City of Albuquerque

December 13, 1979

Re: 8012 Constitution Place N. E.

REVISED DRAINAGE PLAN
SCALE: 1" = 10'
(SEE SHEET C-2 FOR SITE DETAILS & DIMENSIONS)

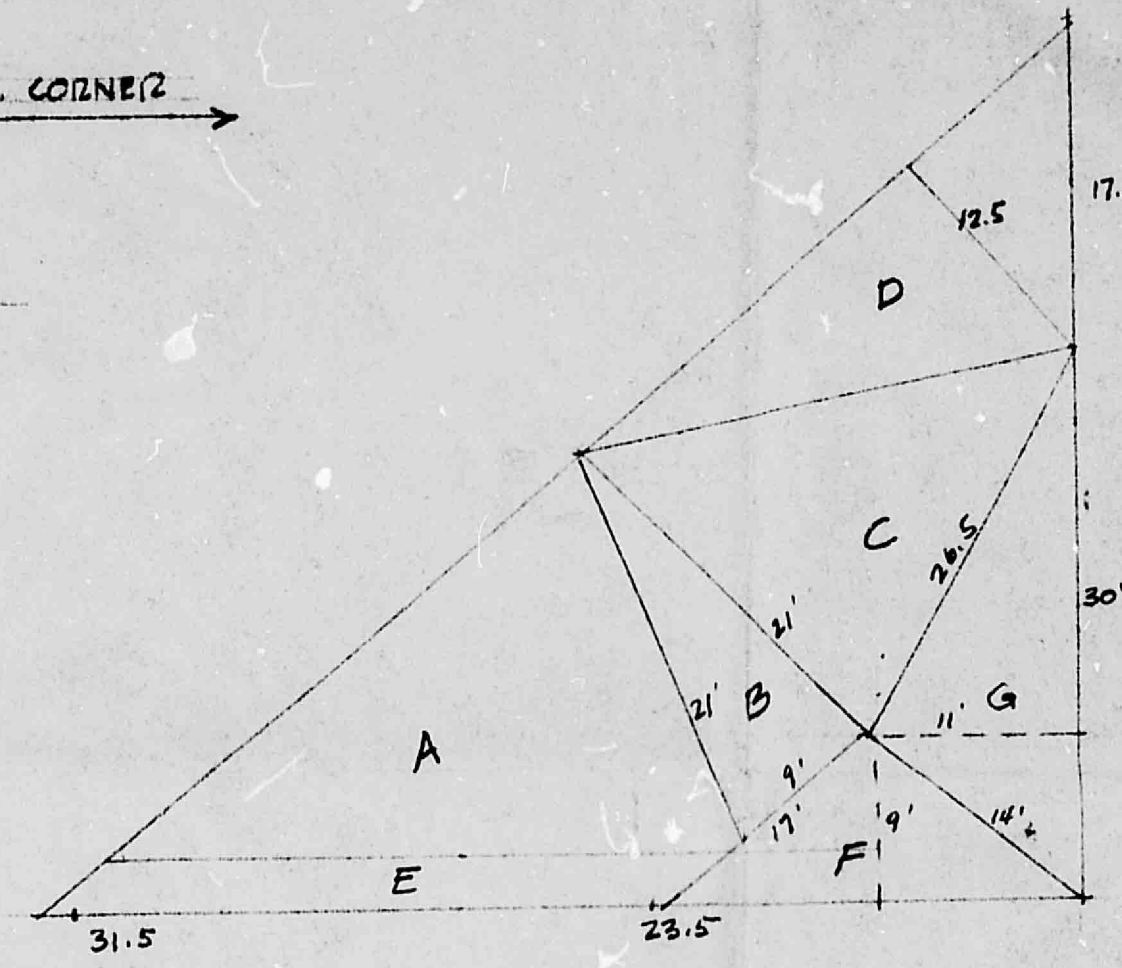
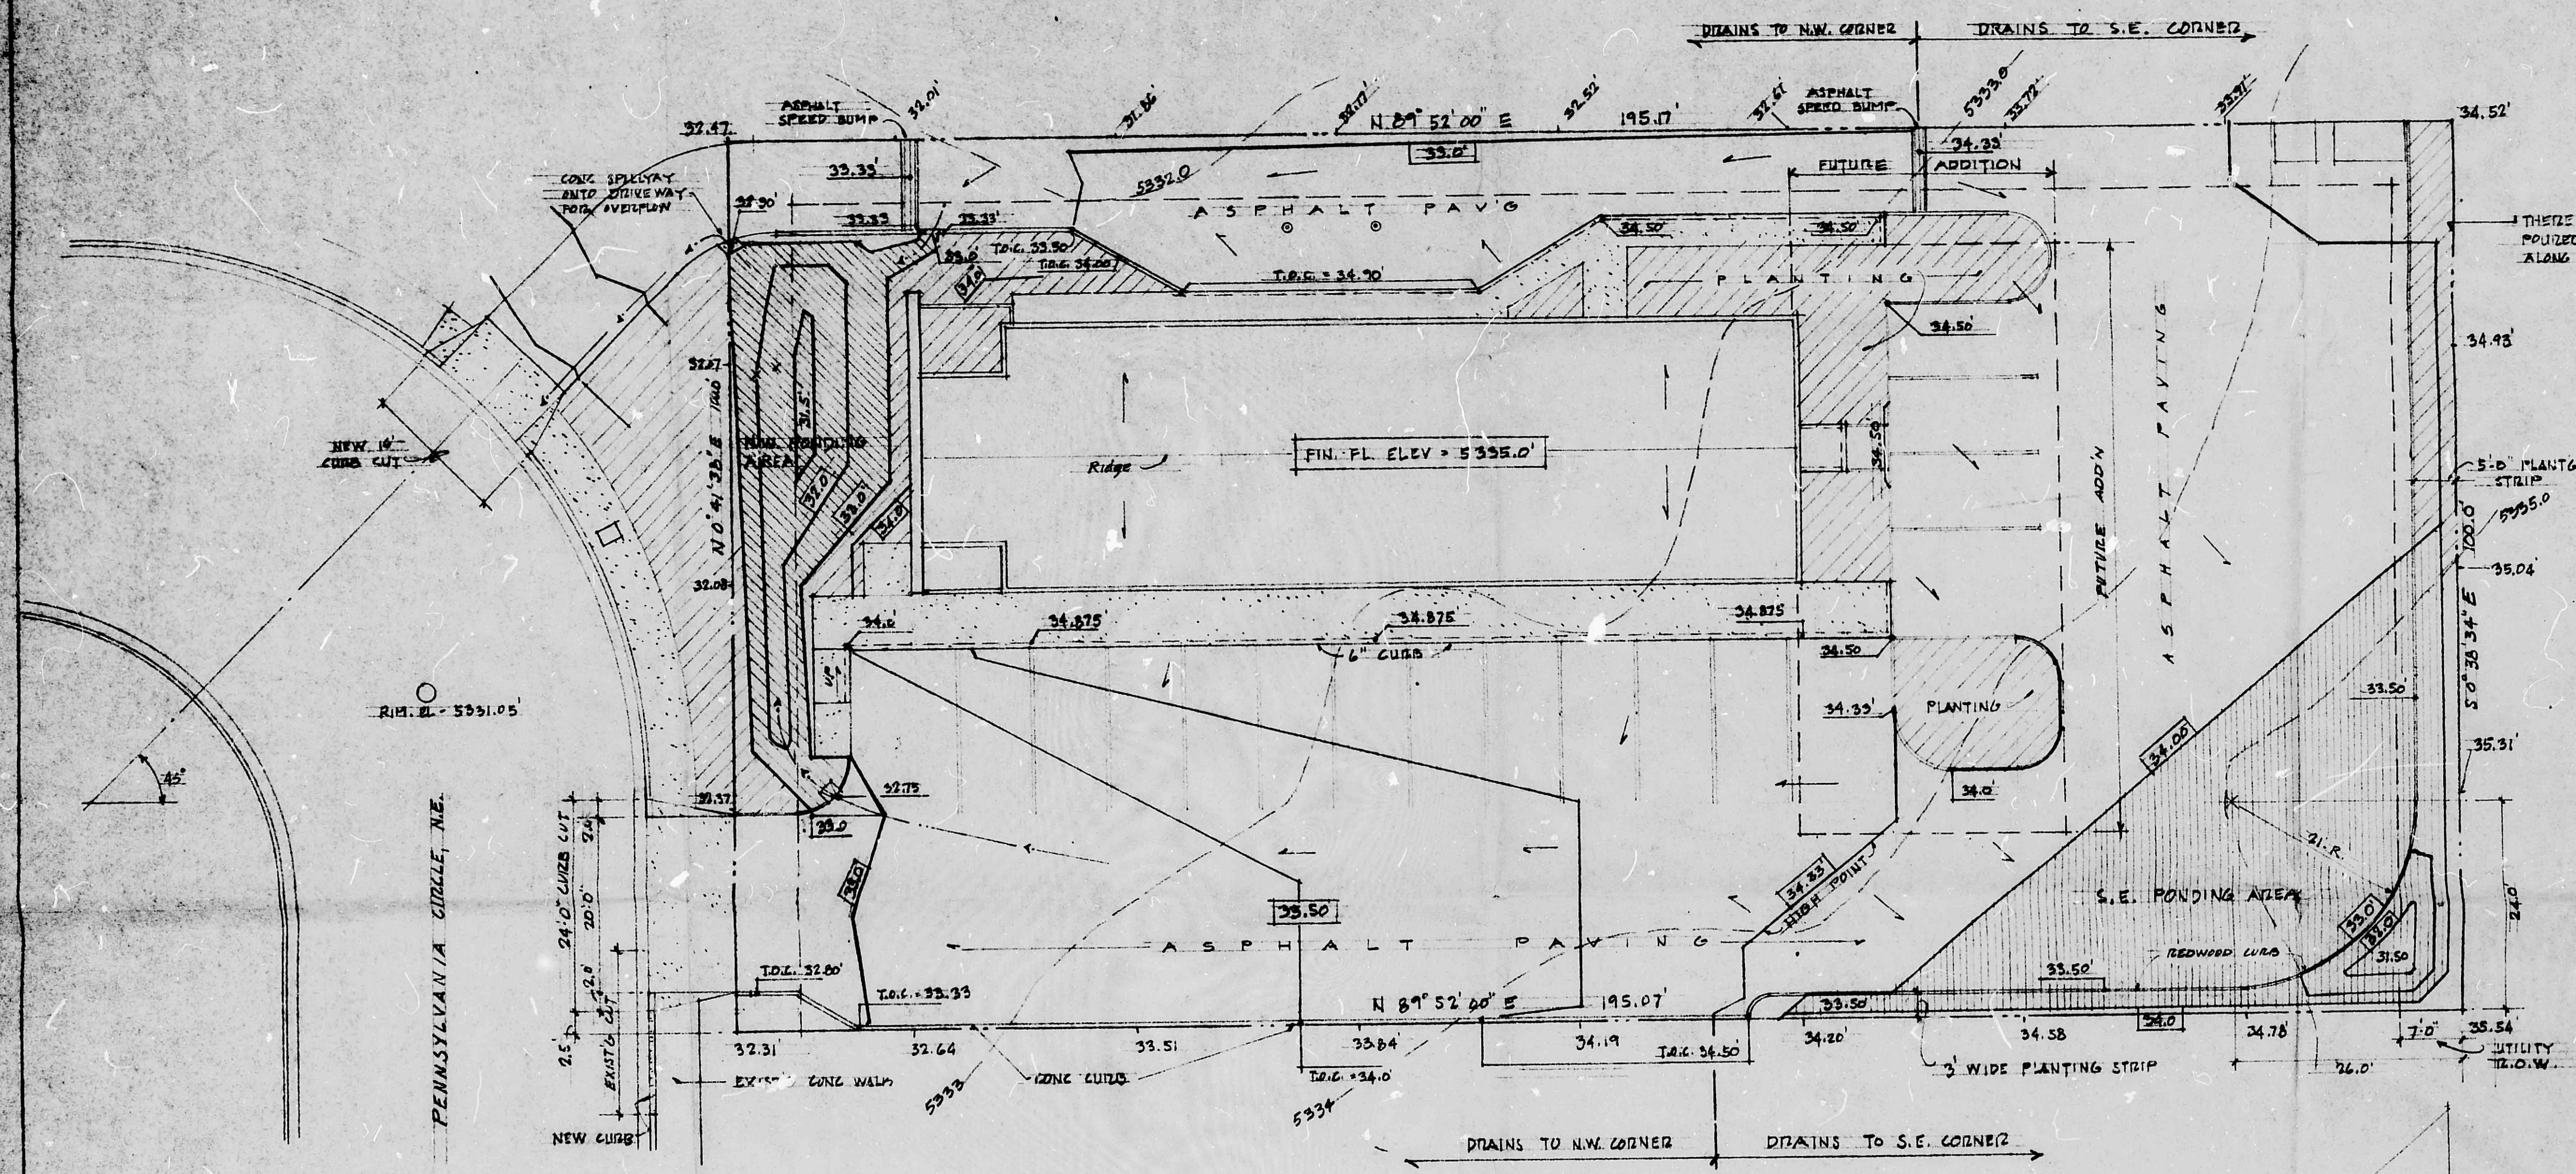
A recent survey of the above referenced address determined that the grading was not in compliance with the grading plan approved by my office. The existing grading is deficient in the ponding volume (minus west pond) required in the approved plan. This situation is in violation of City policy and of the condition under which approval was granted for construction.
